Subject: RE: Planning Consultation on: A/177/19/PL

Engineers Comments Regarding Surface Water Drainage

APPLICATION NO: A/177/19/PL

Site Address: The Vinery Arundel Road Poling BN18 9PY

scale:	1:500 @ A1	client:	Tributes
date:	November 2019	project:	Plot A, The Vinery, Arundel Road, Poling. BN18 9PY.
drawn:	AJC	drawing:	Proposed Drainage Layout
checked:	dp	status:	PLANNING APPLICATION

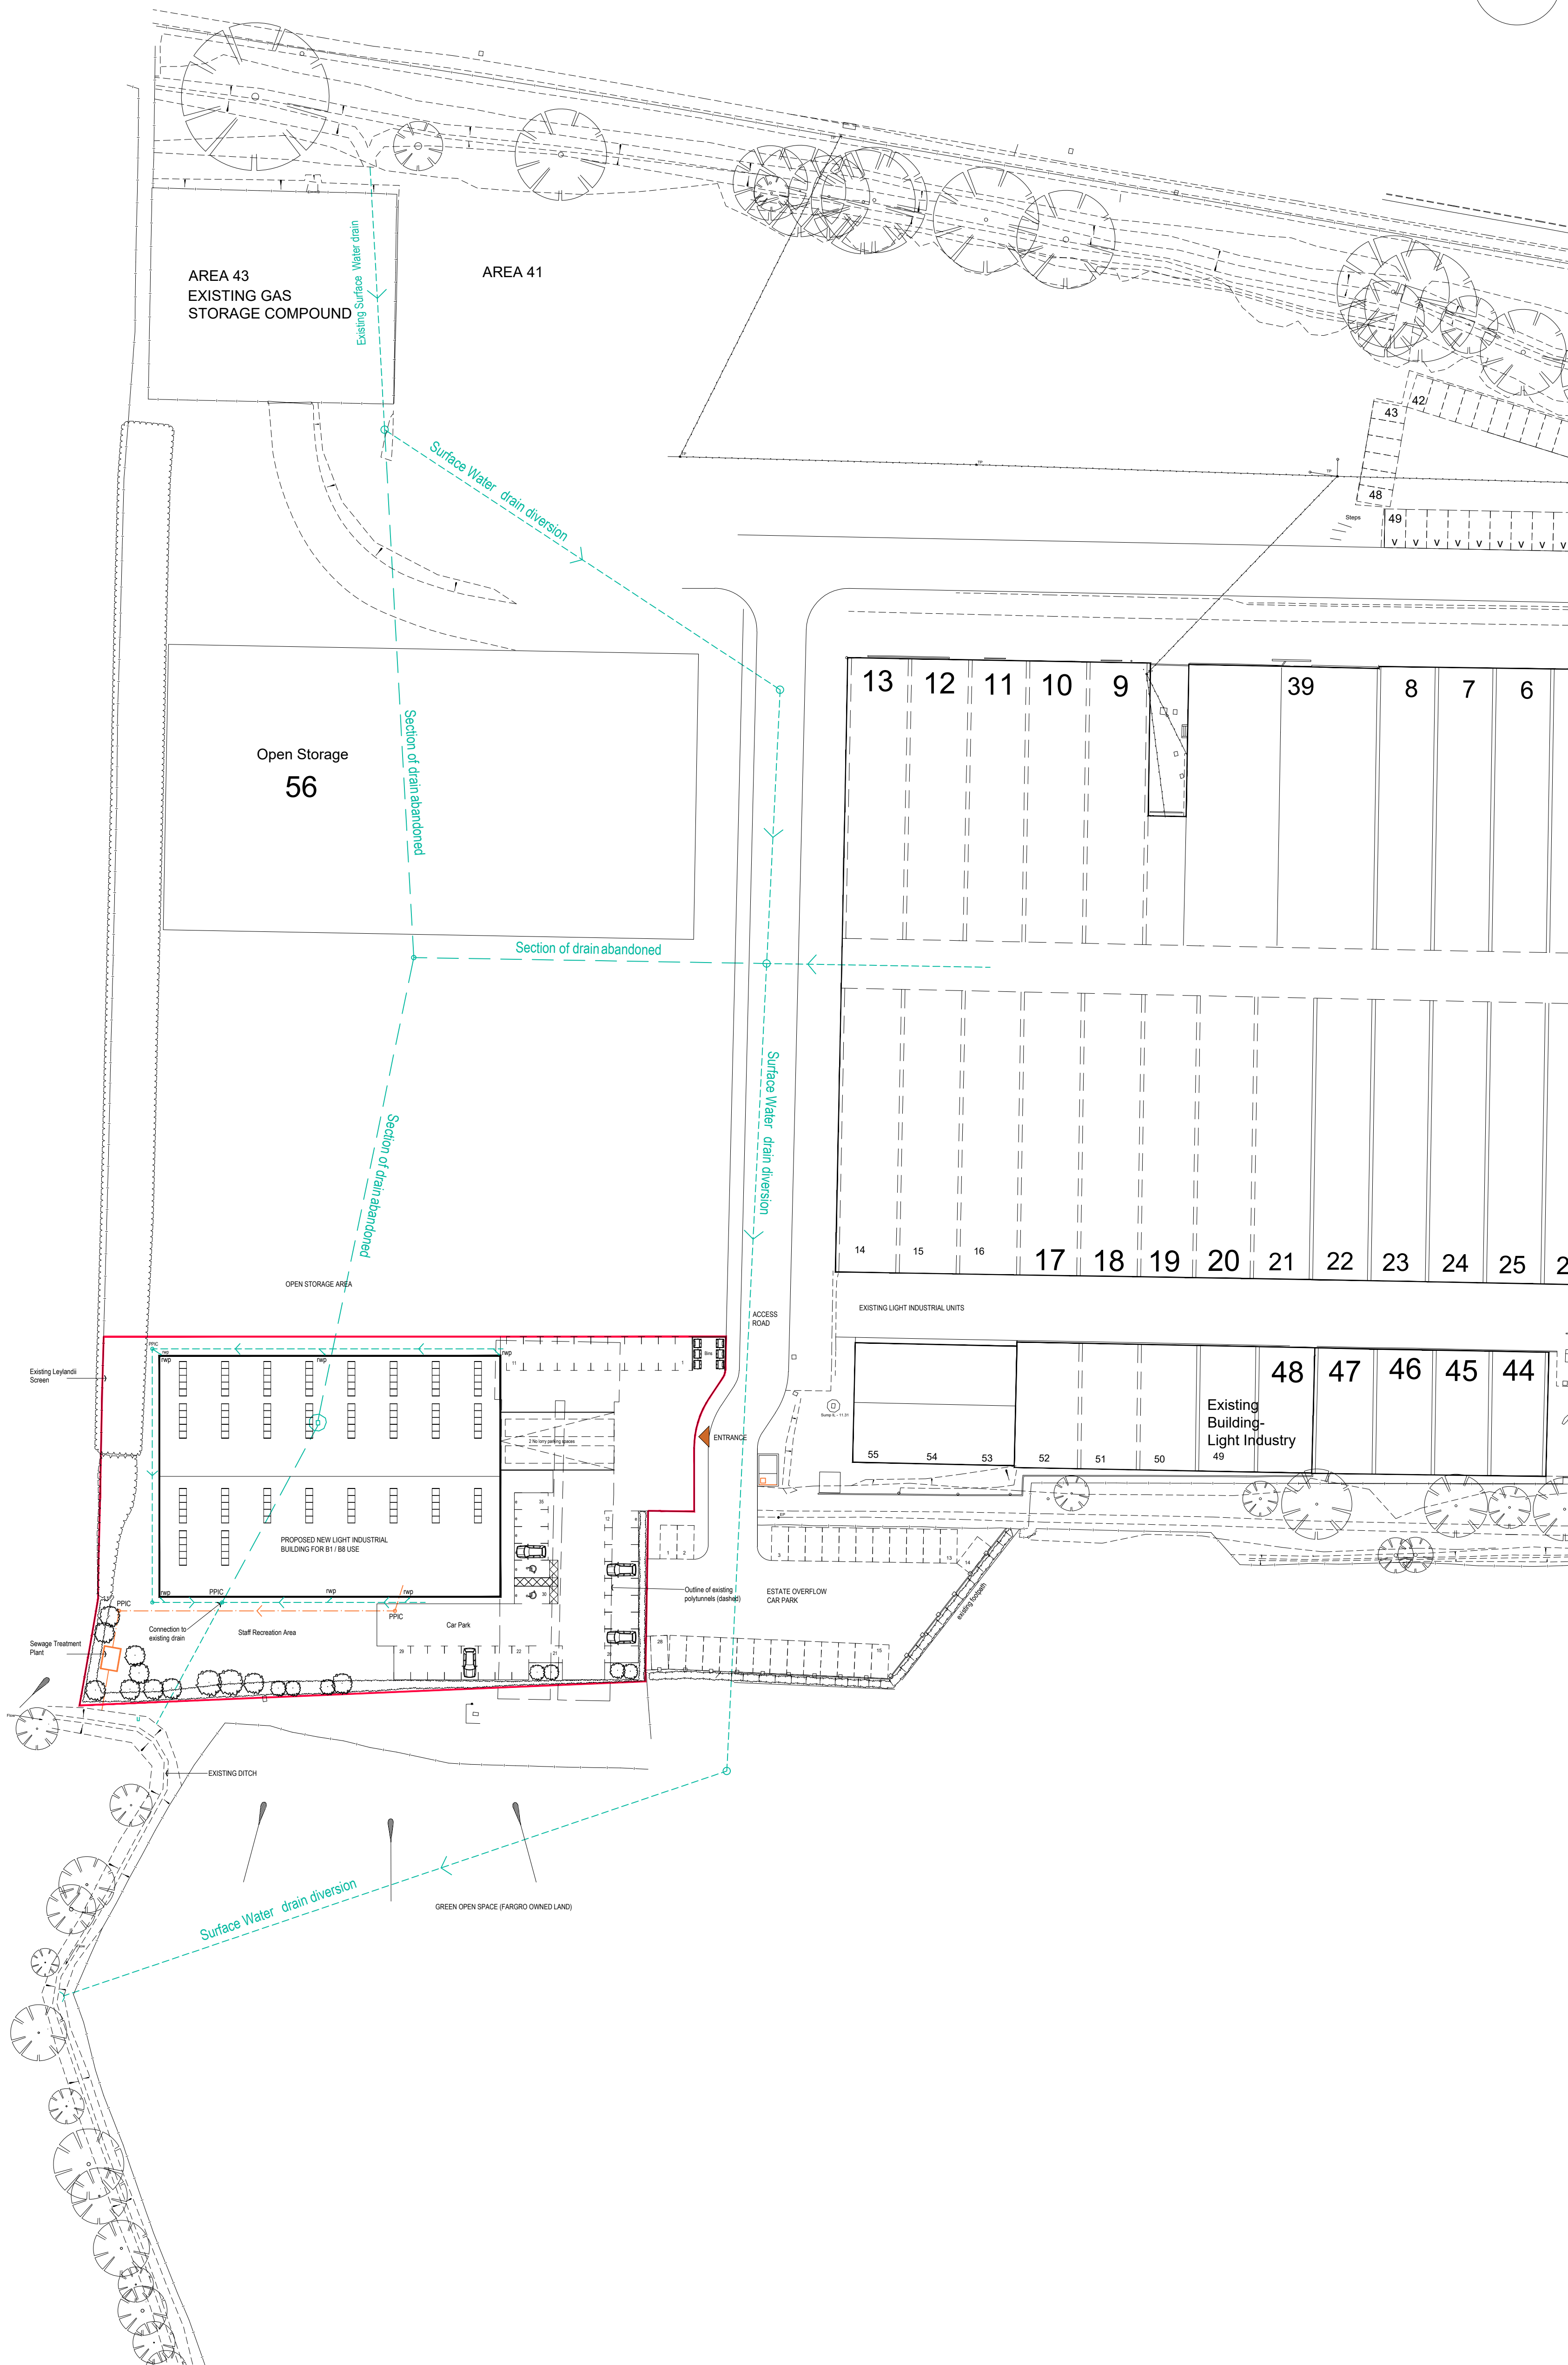
A culverted watercourse crosses the site, whereby the proposed building would be situated over it. This would not be acceptable, however, the applicant has proposed to divert the watercourse clear of the building. It is unclear at this time as to whether this is possible without detrimental loss of hydraulic capacity/flow velocity. The applicant will need to demonstrate that this is a feasible option. Land drainage consent will be also required under the Land Drainage Act 1991.

Any connections to watercourses will also require approval/Land Drainage Consent. It is noted that the applicant is proposing to discharge surface water from the roof area directly into the watercourse without attenuation which would not be acceptable. It is also noted that permeable paving is proposed for the car park but it is unclear as to whether this will discharge via infiltration into the ground?

The surface water design should follow the hierarchy of preference for different types of surface water drainage disposal systems as set out in Approved Document H of the Building Regulations. This must consider infiltration prior to discharging to watercourses, and be designed accordingly, taking into account winter soil infiltration rates and winter groundwater levels. Whilst this will be a Building Regulation requirement, it needs to be considered now, as it will also form part of the Land Drainage Consent.

"The development shall not proceed until details have been submitted to and approved in writing by the Local Planning Authority for any proposals: to discharge flows to watercourses; or for the culverting, diversion, infilling or obstruction of any watercourse on or adjacent to the site. Any discharge to a watercourse must be at a rate no greater than the pre-development run-off values. No construction is permitted, which will restrict current and future land owners from undertaking their riparian maintenance responsibilities in respect to any watercourse or culvert on or adjacent to the site. "
